Permit Number: 020703

This is to certify that Shalom House Inc /Hall, Lar  
has permission to Replace stair support/reinforce porch be  
AT 130 Park St 045 A010001

Permit Nbr 02-0703 Location of Construction 130 Park St Appl. Date  
Status Hold Permit Type Alterations - Dwellings Issue Date  
CBL 045 A010001 Territory Nbr 2 Estimated Cost \$4,000.00 Date Closed

BACK STAIR Revised

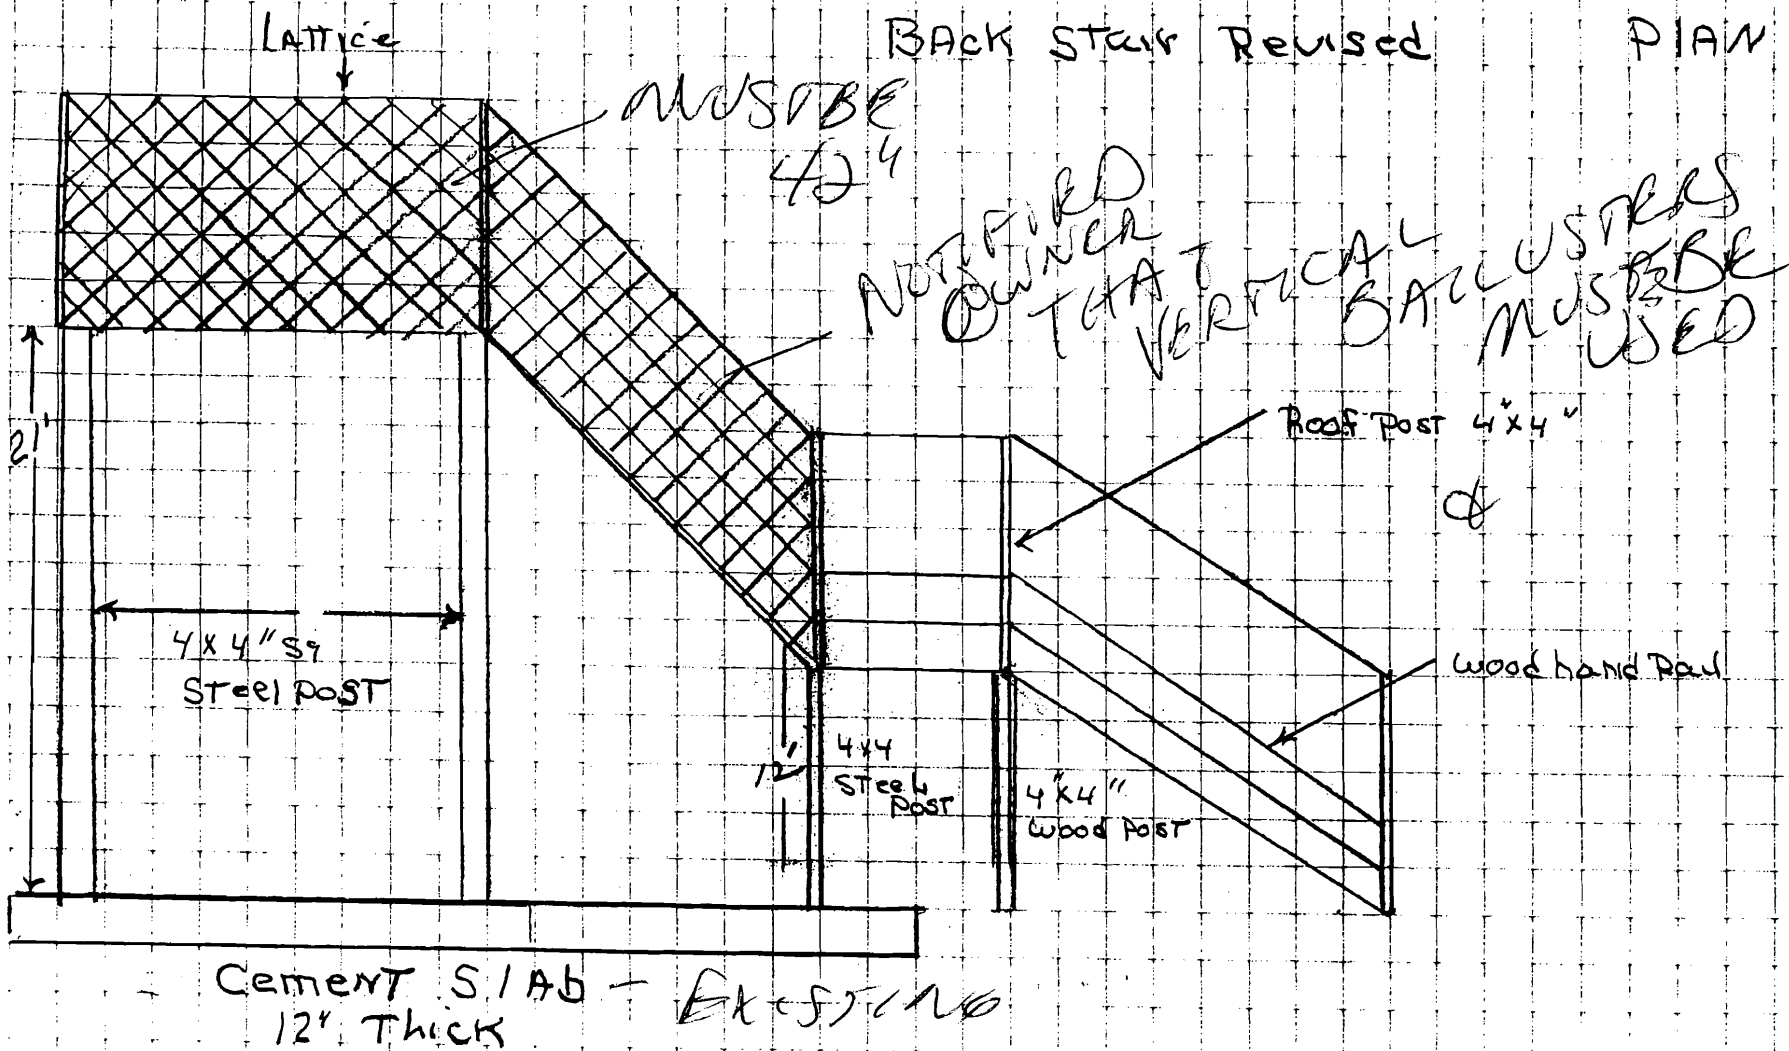
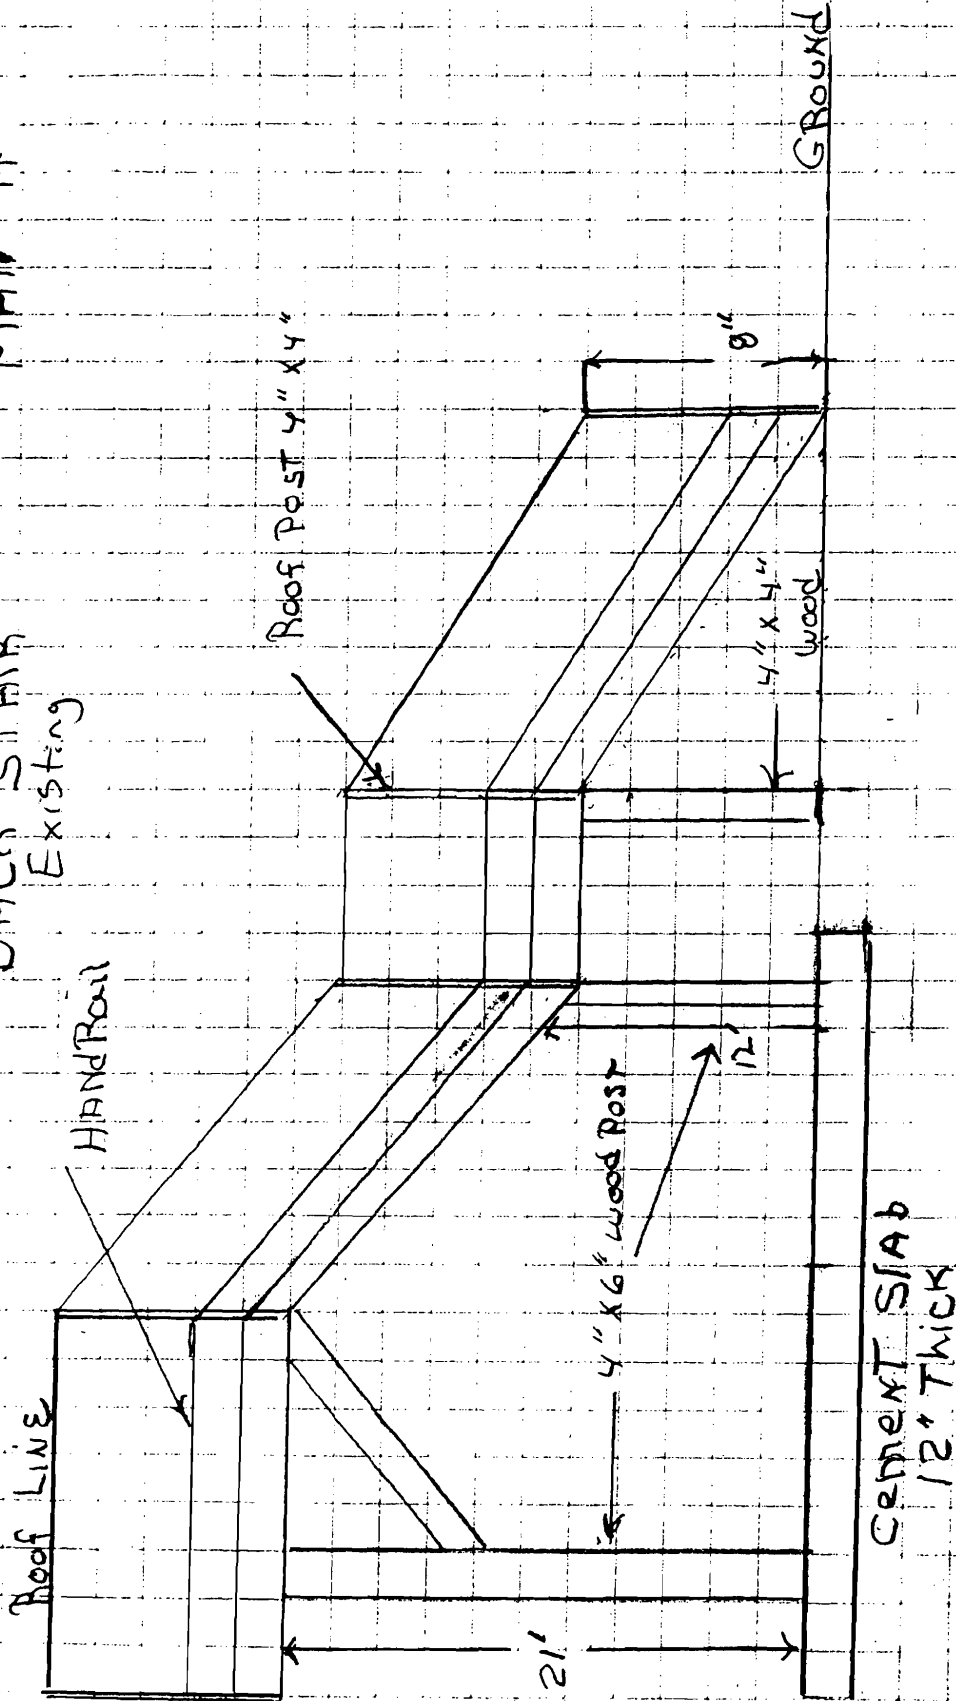
Comment Date	Comment	Add	Delete	Save
07/26/2002	Foundation fails to comply with frost depth/protection.			
	Name mjn	Follow Up Date		Completed
07/26/2002	Guards as designed provide a ladder effect, permit on hold until suitable design is submitted			
	Name mjn	Follow Up Date		Completed
